RE: Harnett County Land Use Existing Tank Application #10-5-24704

The Harnett County Department of Public Health, Environmental Health Division evaluated the above referenced property at the site designated on the plat/site plan that accompanied your existing tank application. According to your application requesting a garage, the evaluation was done in accordance with the laws and rules governing wastewater systems in North Carolina General Statute 18A.1950 including related statutes and Title 15A, Subchapter 18A, of the North Carolina Administrative Code, Rule.1950 and related rules.

SITE PLAN APPROVAL
 DISTRICT *RA 20k USE*
 #BEDROOMS *24x2600' bar, 8pk Bedrooms*
 Date *6-28-10*
 Zoning Administrator *N.C. Hill*

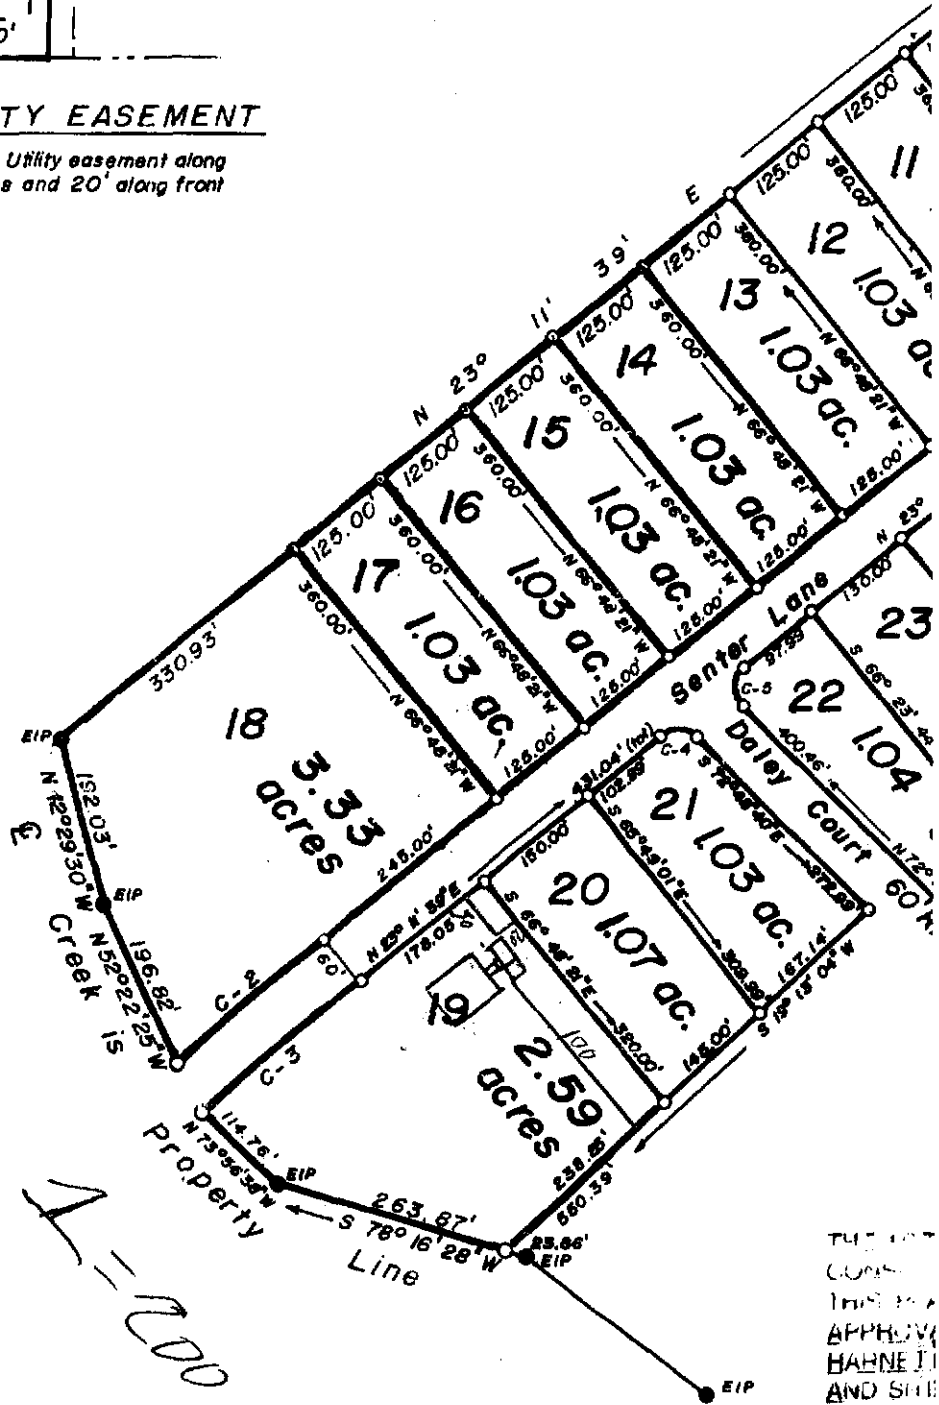
Based on the criteria set out in Title 15A, Subchapter 18A, of the North Carolina Administrative Code, Rules .1950, the evaluation indicated that the site is **UNSUITABLE** for the addition requested. Therefore, your request for an existing tank is **DENIED**. The site is denied based on the following:

- _____ 15A NCAC 18A.1950a {16} - Any swimming pool must be 15' from any part of septic system.
- _____ 15A NCAC 18.1945{b} - Each lot shall have original septic system plus repair area.
- _____ 15A NCAC 18A.1950 {10} - Any building to be 5' from drain line.
- X 15A NCAC 18A.1950{c} - Nitrification fields and repair areas shall not be located under paved areas or areas subject to vehicular traffic.
